CITY OF ALBUQUERQUE

Re: The 24's @ Uptown
2424 Louisiana Blvd NE
Traffic Circulation Layout
Architect's Stamp 05-23-17 (H19D001)

Based upon the information provided in your submittal received 9-5-17, the above referenced plan cannot be approved for Building Permit until the following comments are addressed:

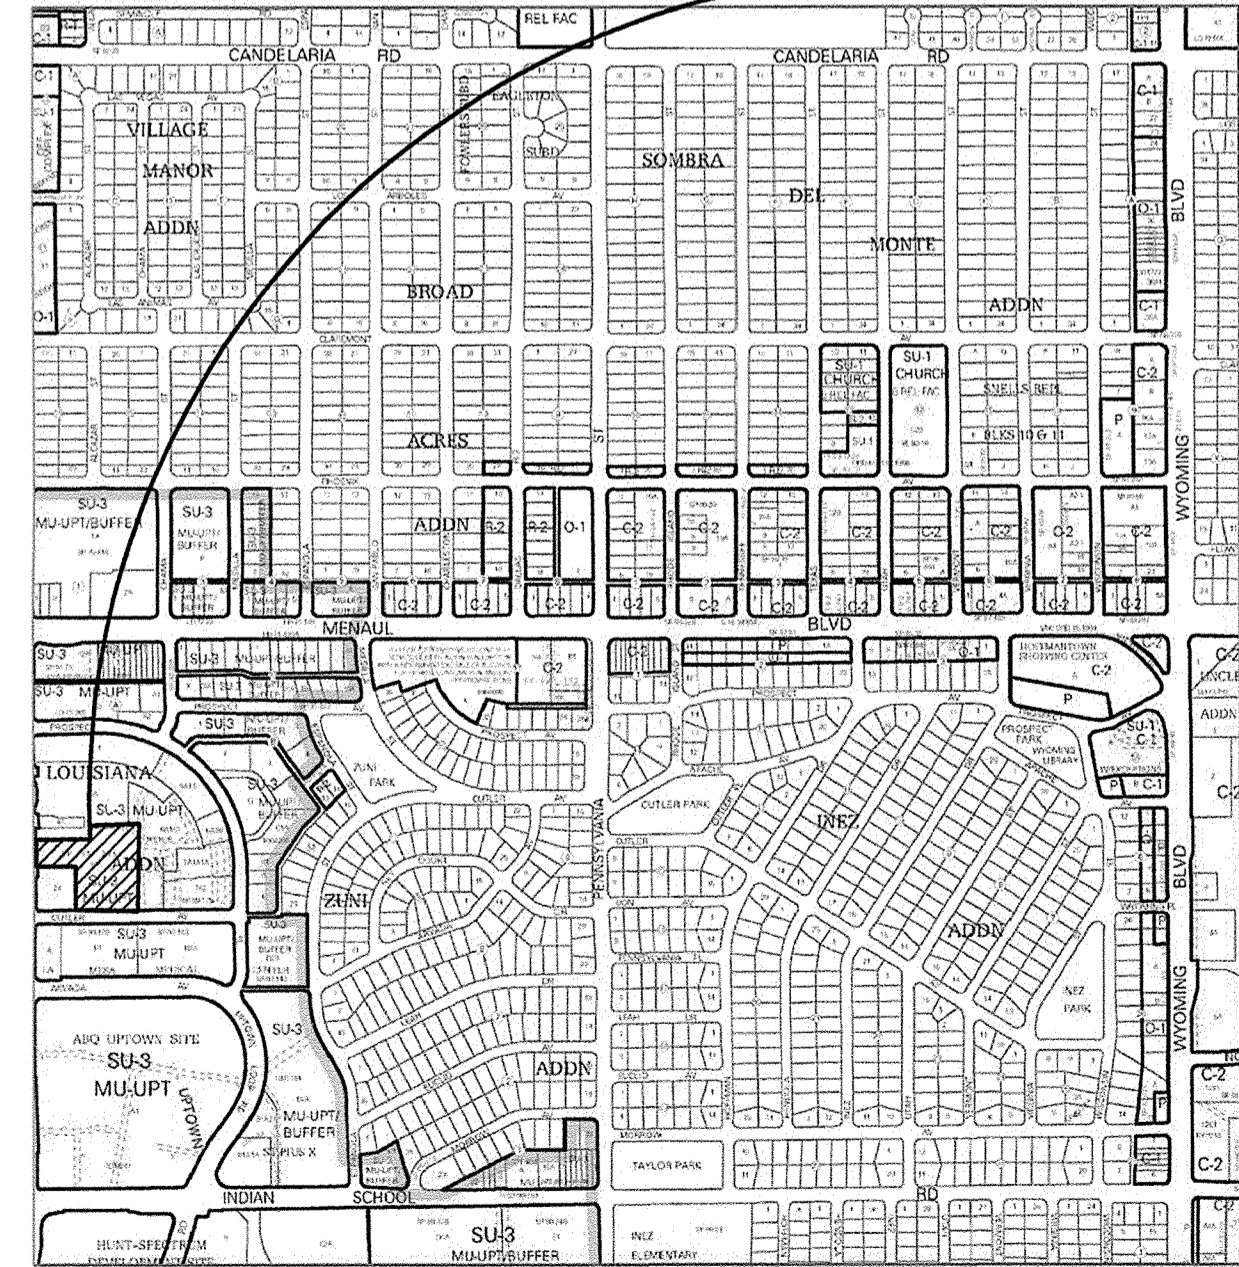
1. The ADA accessible parking sign must have the required language per 66-7-352.4C NMSA 1978 **"Violators Are Subject to a Fine and/or Towing."** Please call out detail and location of HC signs.
2. The ADA access aisles shall have the words **"NO PARKING"** in capital letters, each of which shall be at least one foot high and at least two inches wide, placed at the rear of the parking space so as to be close to where an adjacent vehicle's rear tire would be placed. (66-1-4.1.B NMSA 1978)
3. Per DPM, a 6 ft. wide ADA accessible pedestrian pathway is required from the HC parking stall access aisles to the building entrances. Please dimension all ADA access aisles.
4. One-way vehicular paths require pavement directional signage and a posted **"Do Not Enter"** sign at the point of egress. Please show detail and location of posted signs for all one way paths.
